**Addendum No. 1**

RE: Contract # C204687

1 SECTION OF US-64 BUS, 1 SECTION OF NC-97, AND 70 SECTIONS OF  
SECONDARY ROADS.

**December 21, 2021 Letting**

**TYPICAL SECTION NO. 1**

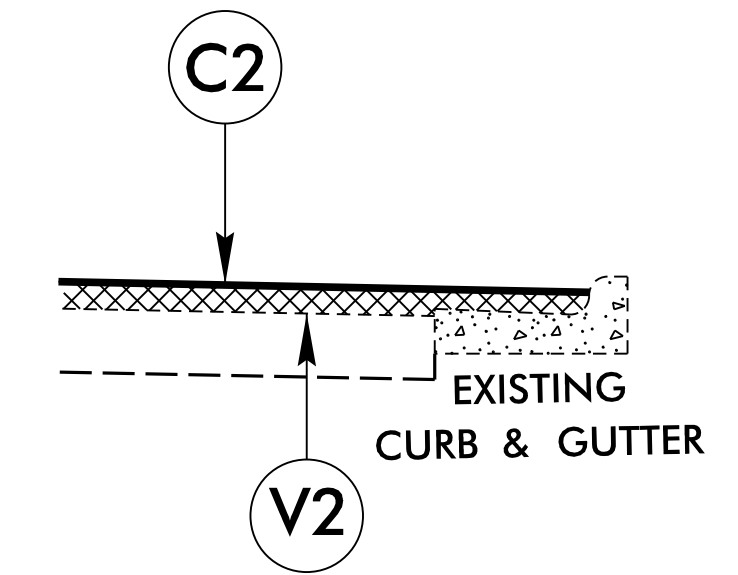
Sheet No.	Revision
37, 39, 41, 43	Revised Summary of Quantity Sheets. Typical Section reference changed from Typical Section No. 5 to Typical Section No. 1 for Maps 48, 49, 50, and 52.
